Martin Nugent
01254 828060
D3/11/0939

**Planning Application, Ribble Valley District
3/11/0939 Otter House, 9 Mitton Road, Whalley**

Block Plan
Scale 1:100

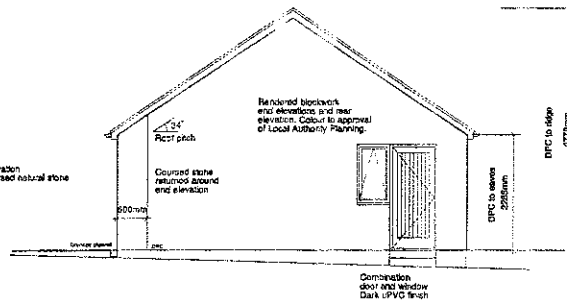
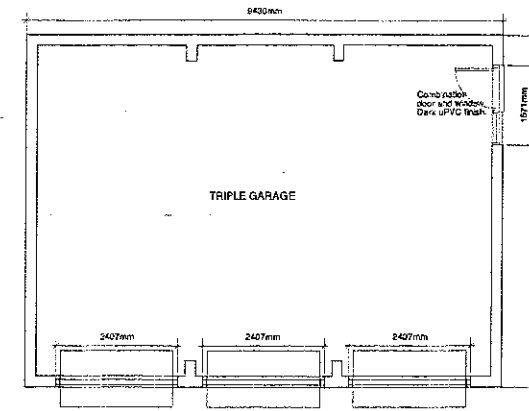
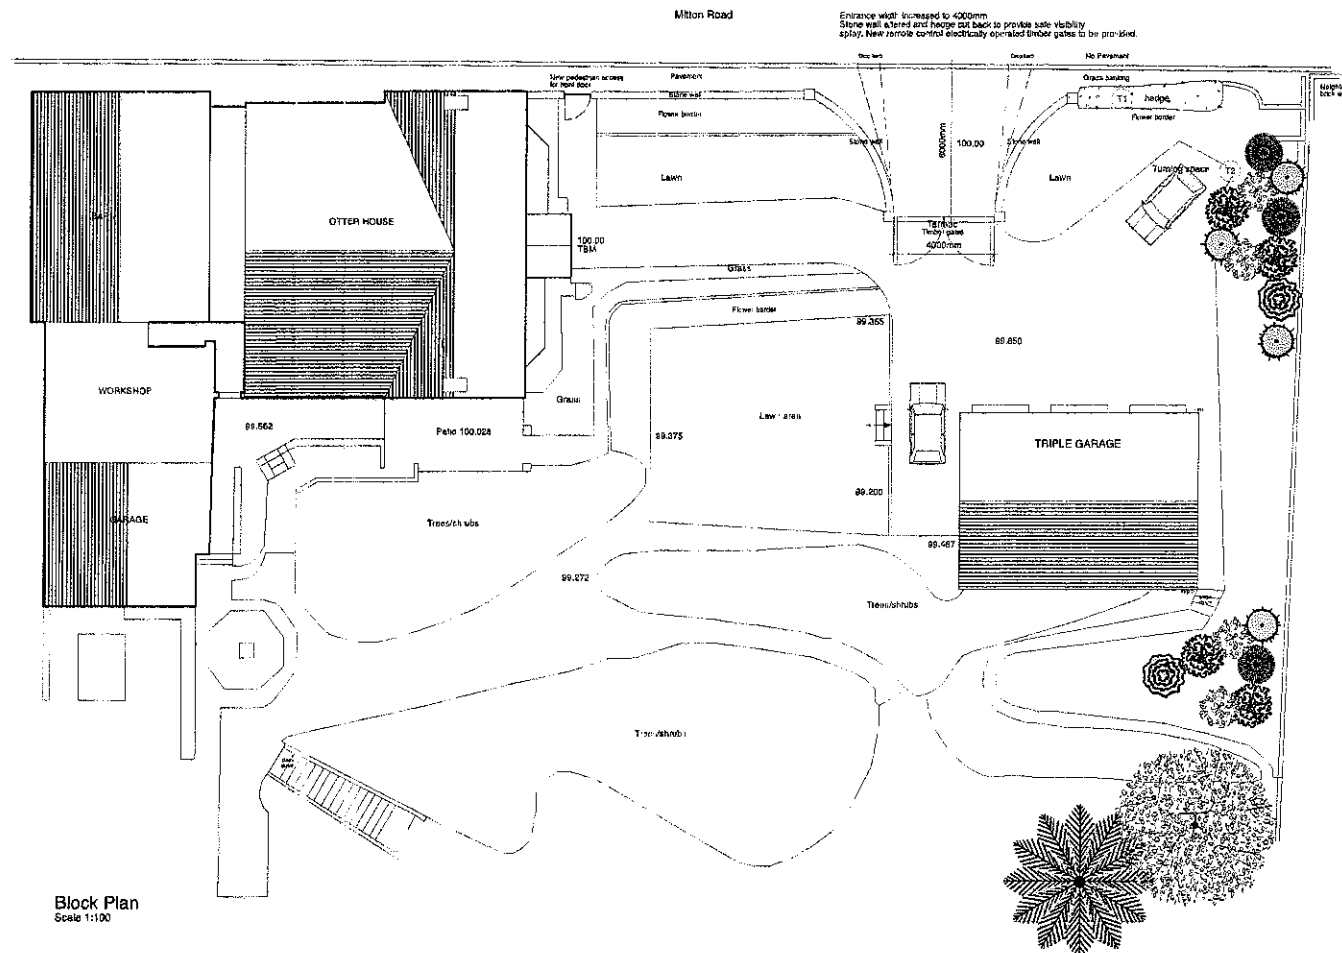
While I welcome the proposed access improvements there is no indication of the sightlines that will be secured as a result of these changes. In view of the highway characteristics at this location, I would recommend a minimal visibility splay of 40m in either direction, to be measured from 2.0m back from the edge of carriageway. The inclusion of the relevant dimensions on an amended site plan would be satisfactory.
